CITY OF ALBUQUERQUE

June 9, 2015

**RE: Jackson-Wink MMA Academy
Grading and Drainage Plan & Report
Engineers Stamp Date 5/8/15 (K14-D005)**

POND OUTLET DETAIL

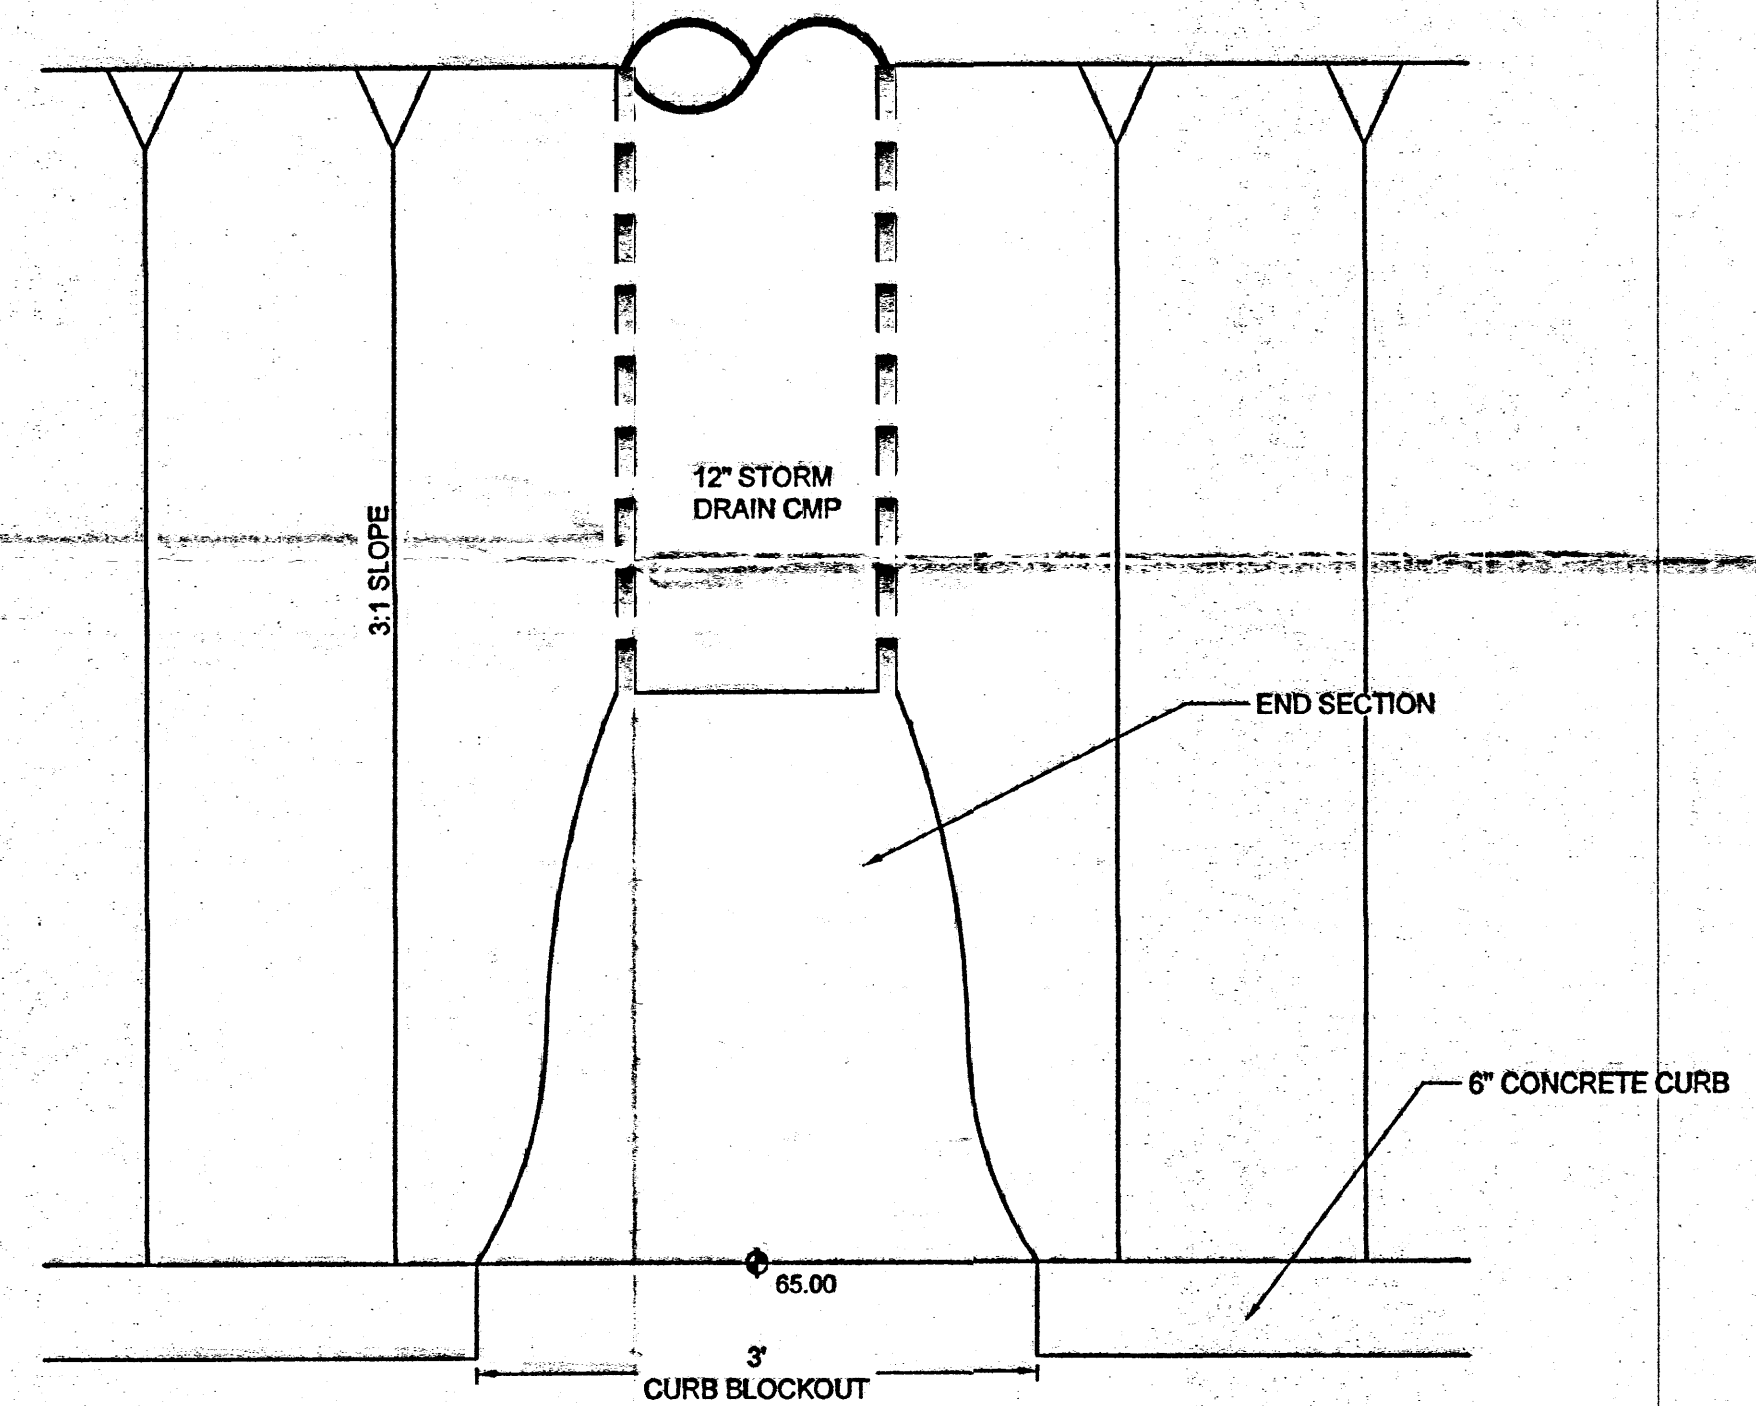
- The flows leaving the south side of the structure need to pass through a landscape buffer before leaving the site via the proposed 12" pipe into the storm sewer system. The 12" pipe should be extended into the landscape area, which is to remain, with a stand pipe and beehive cap.
